CITY OF ALBUQUERQUE

DRB Comments

PROJECT # 1006845

RE: Lot 3, Garden Acres Addition

**PLAT OF
LOT 3A & LOT 3B
GARDEN ACRES ADDITION**

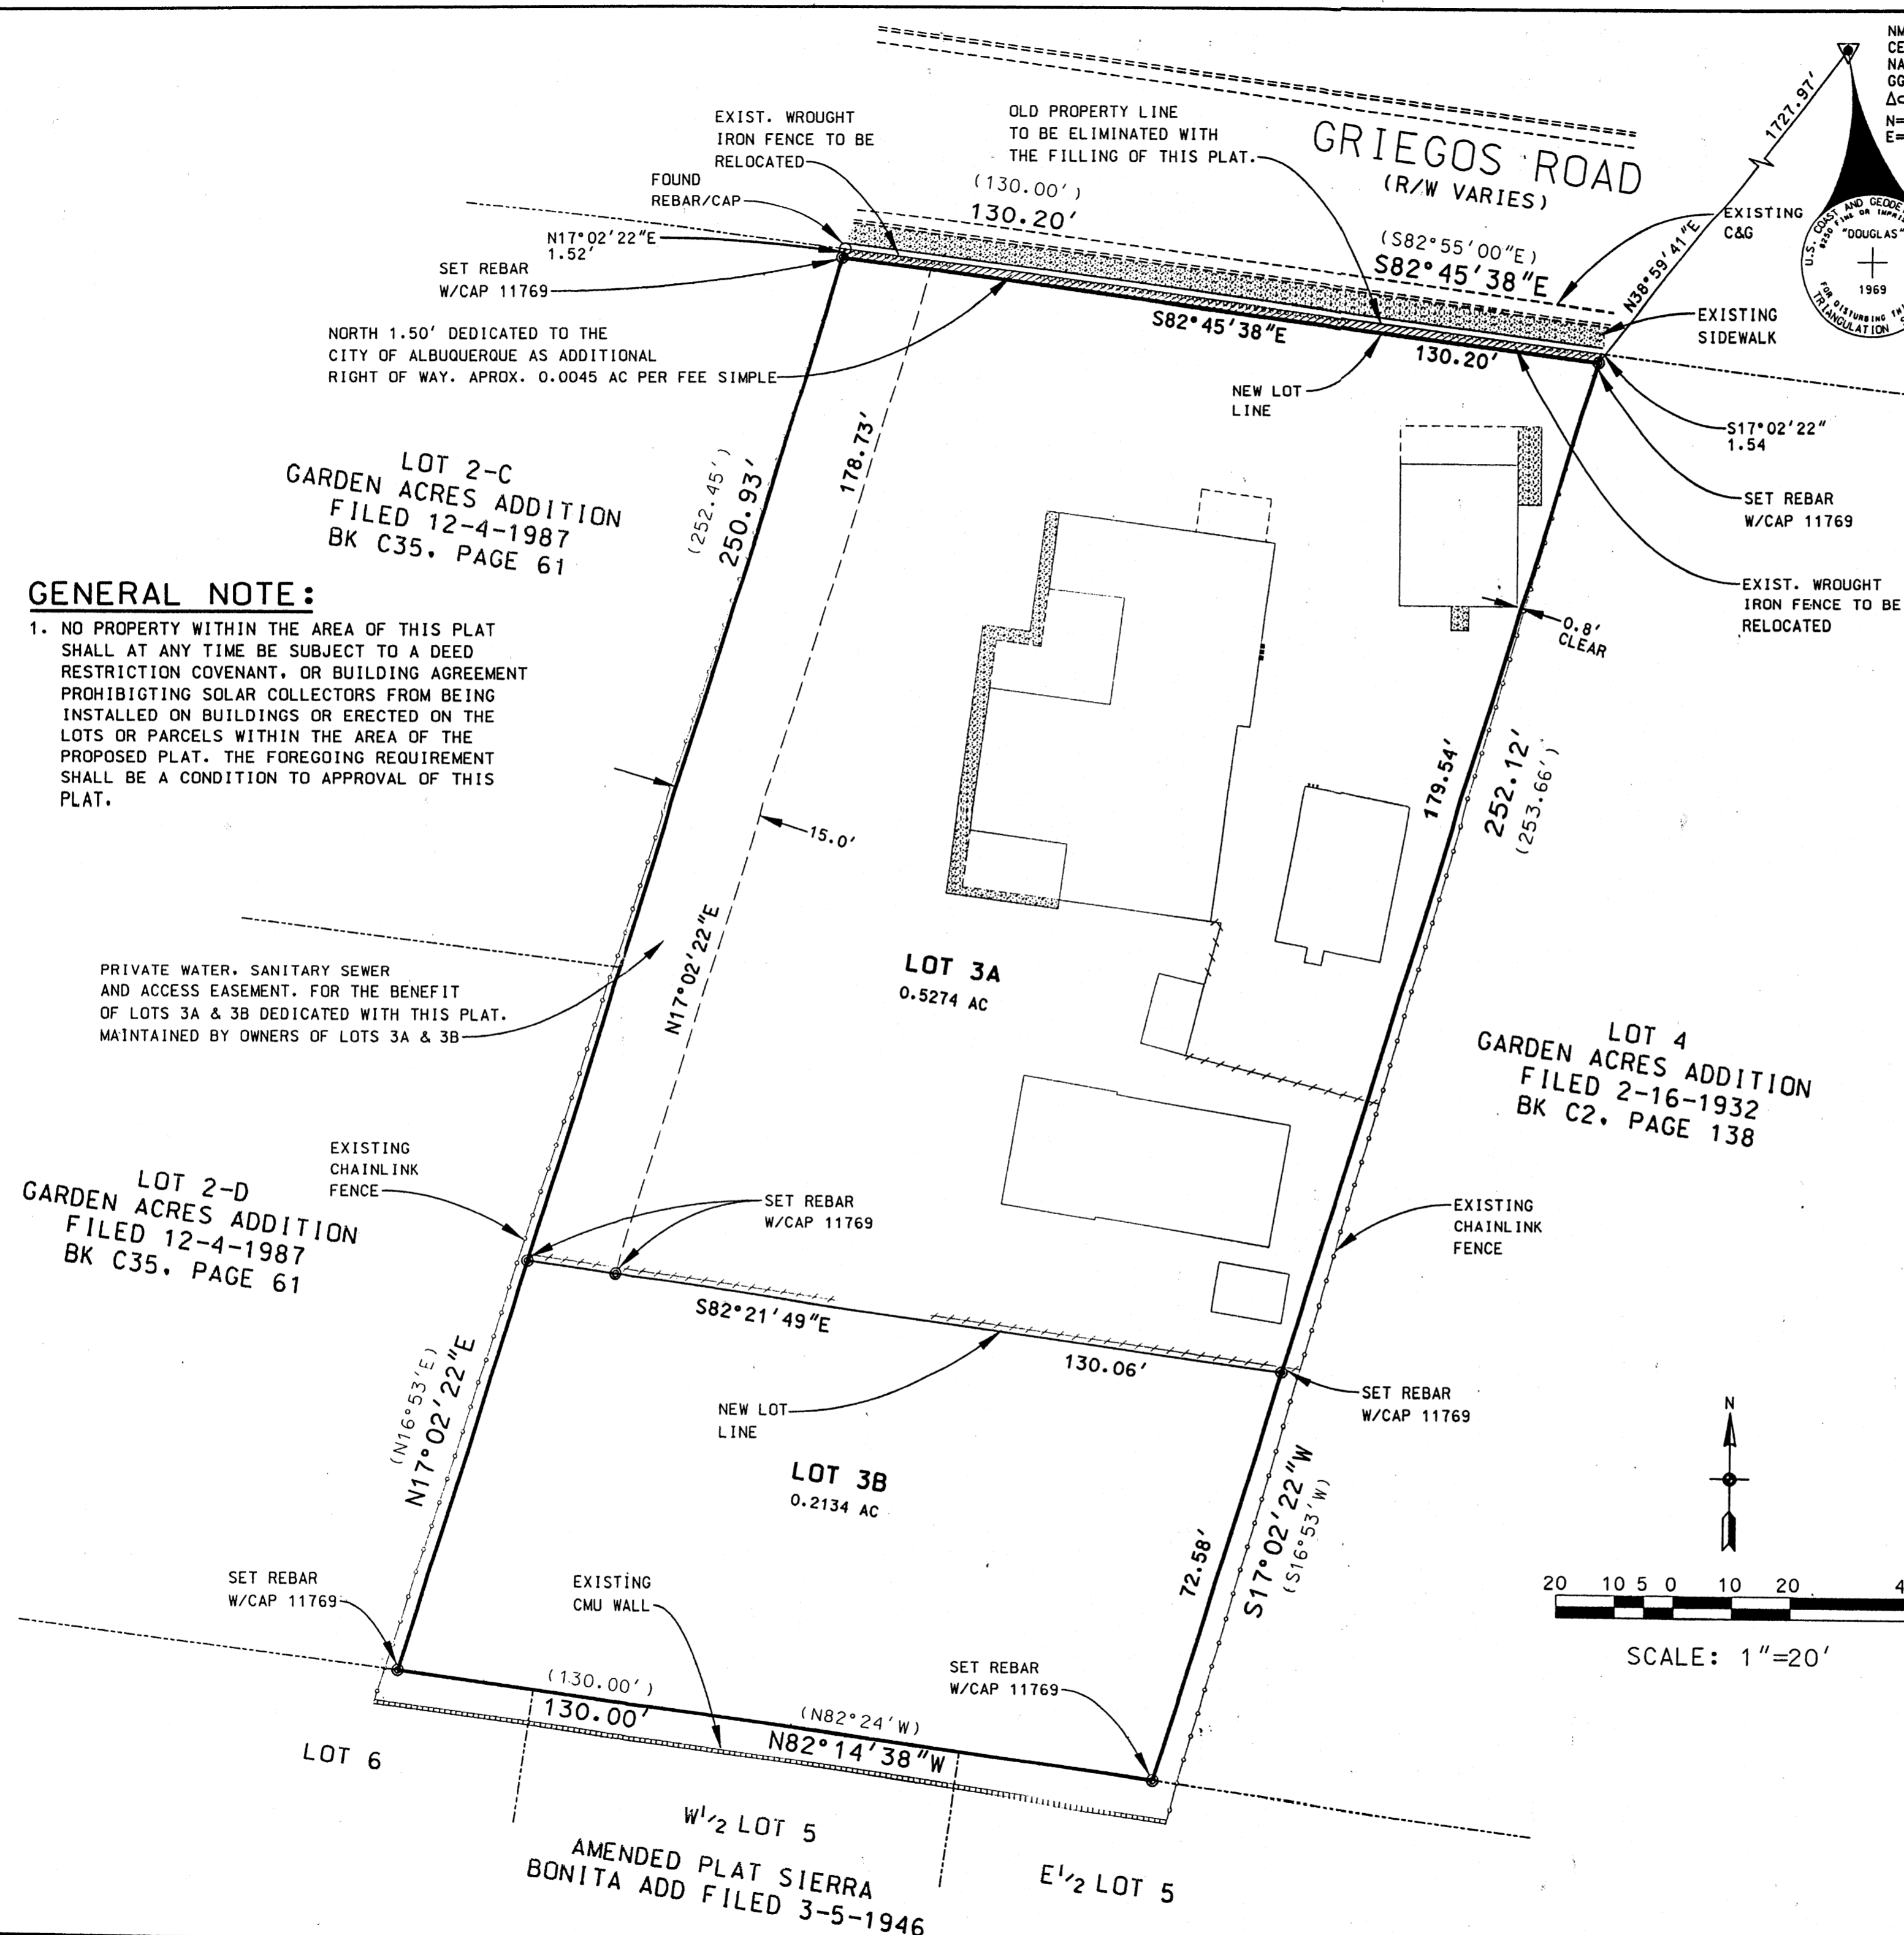
Access to the proposed rear lot must be from an easement over the front lot in order to meet lot width requirements. Existing curb cut should be used for access easement.

There appears to be a more recent subdivision adjoining this property to the west (Replat of Lot 2), which should be referenced on this plat.

For future reference, please revise Solar Restrictions Note to be specific to this type of request, i.e. replace the words "REQUESTED FINAL ACTION" with the words "THIS PLAT" at the beginning of the note, and delete the words "OR SITE DEVELOPMENT PLAN FOR SUBDIVISION" at the end of the note.

SKETCH PLAT

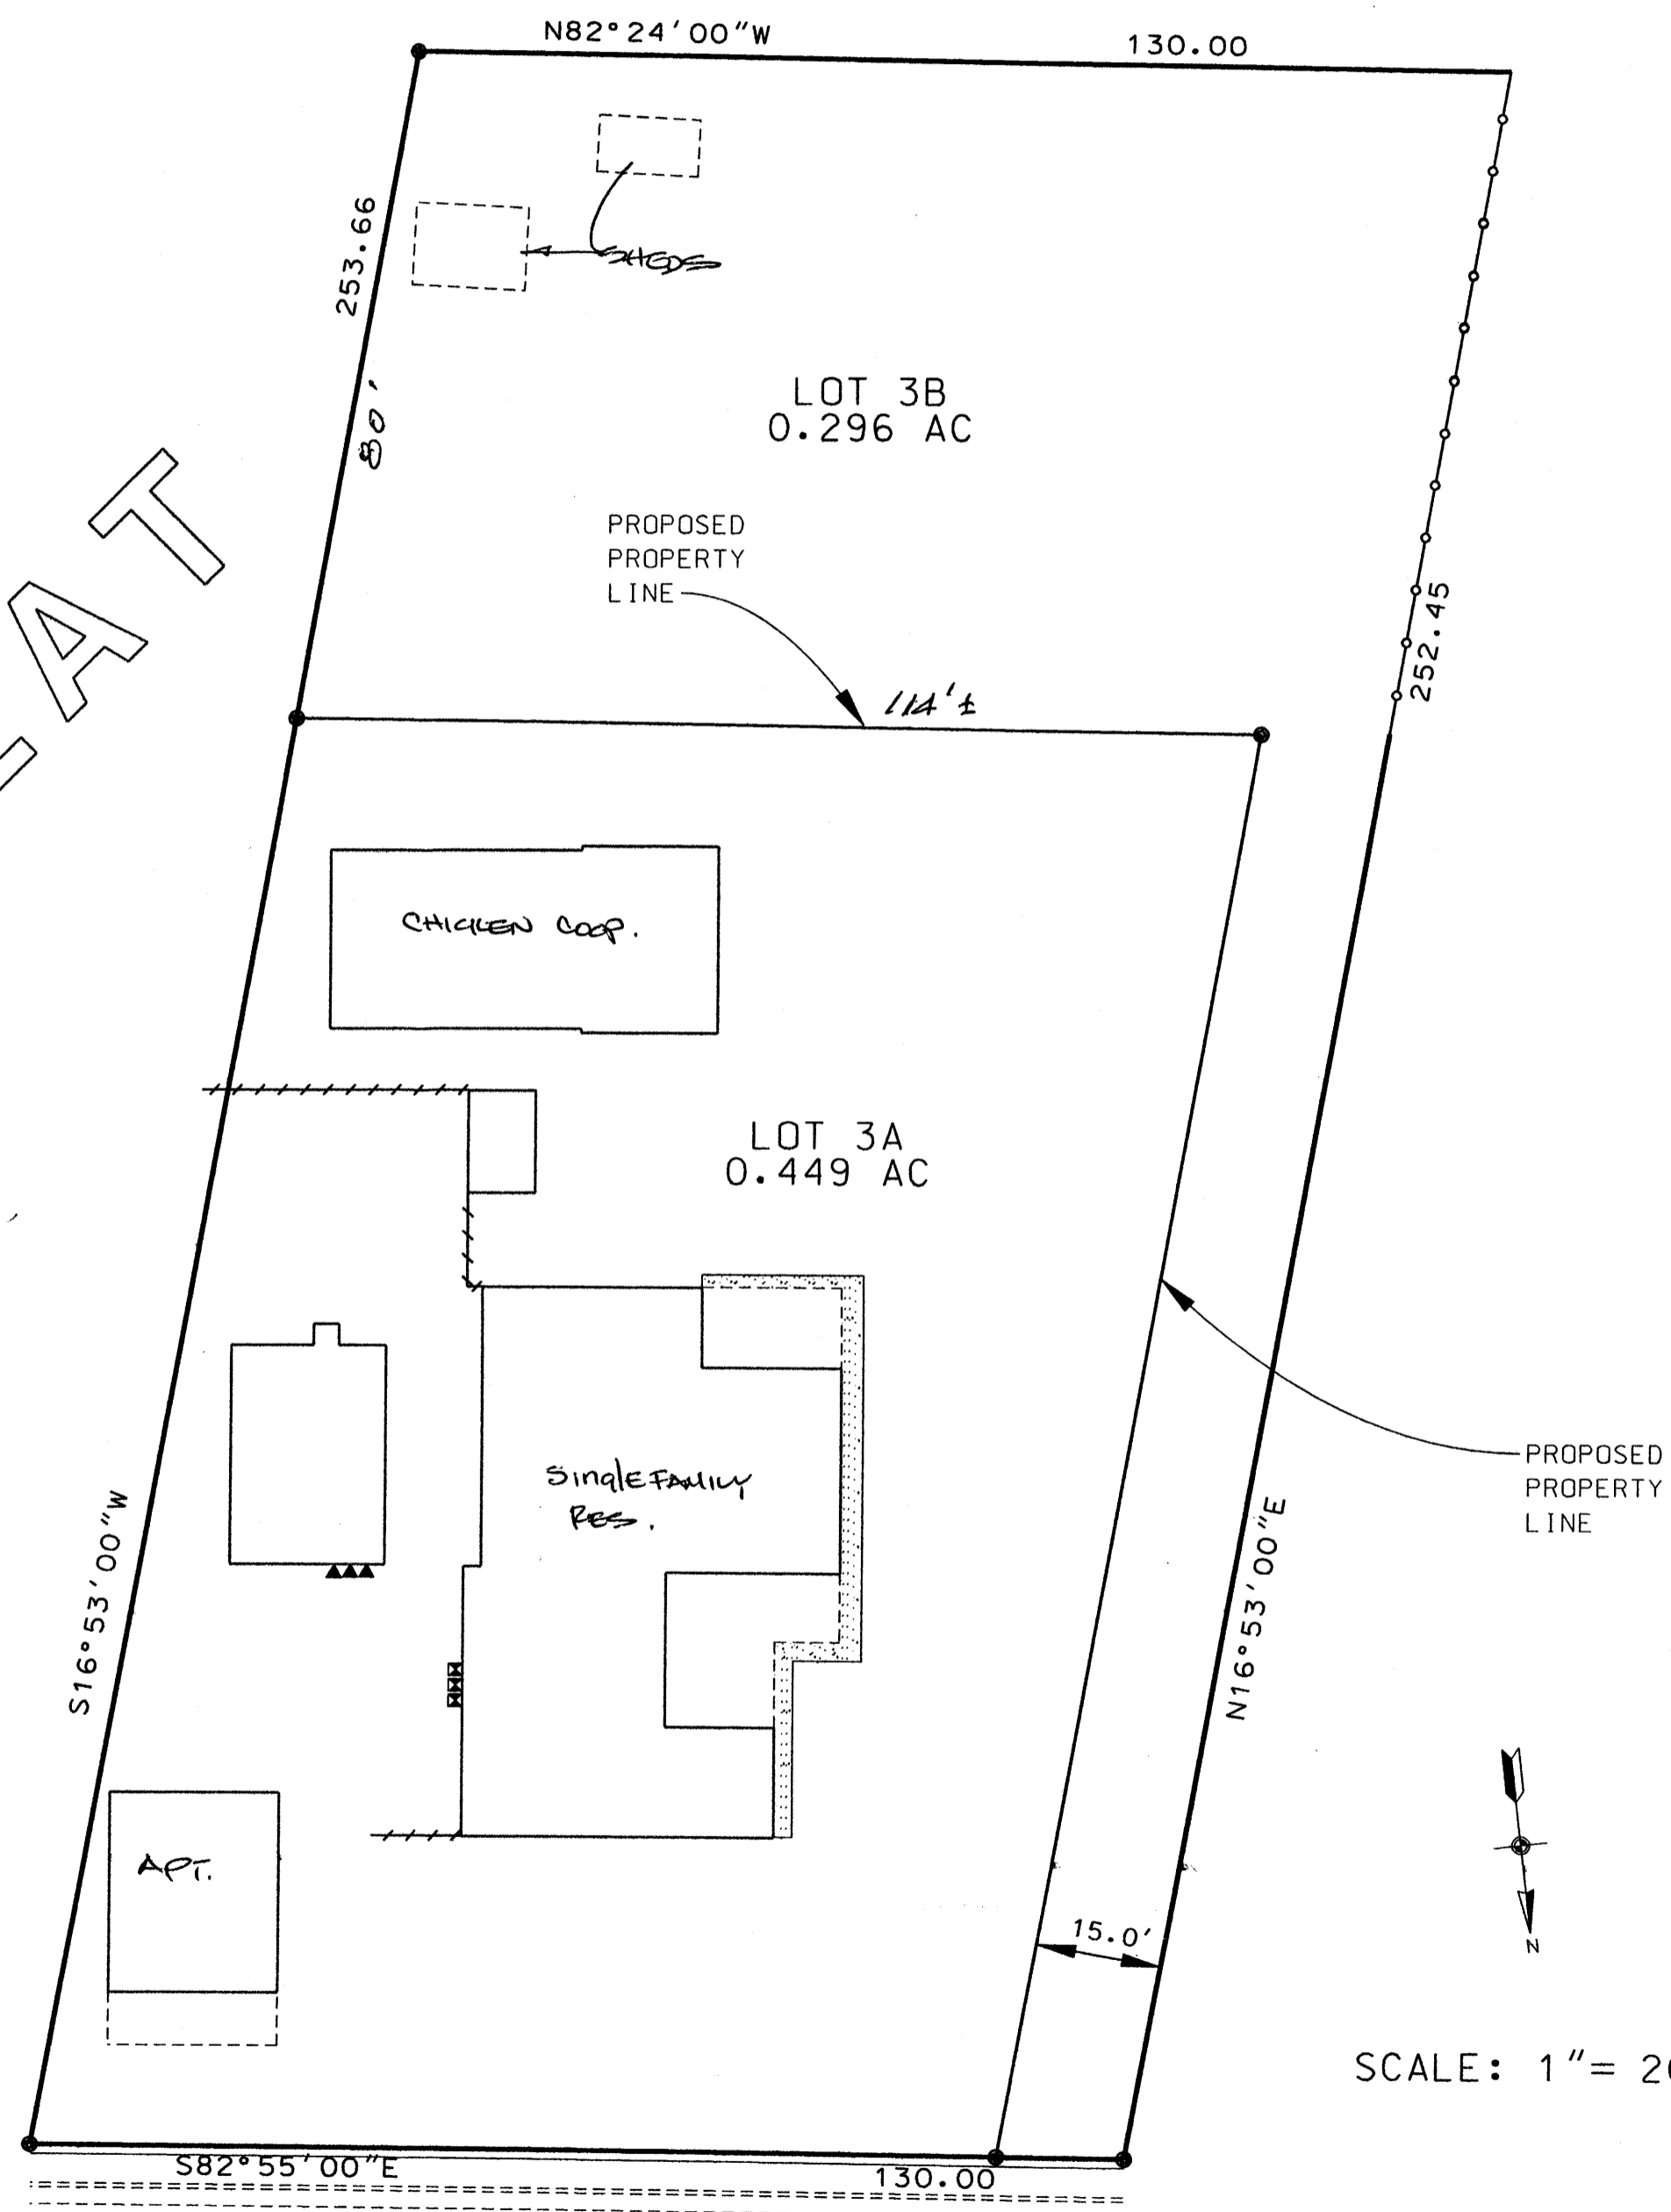
No.	Comment
1.	R/W dedication along Gregos is likely.
2.	SDWK existing?
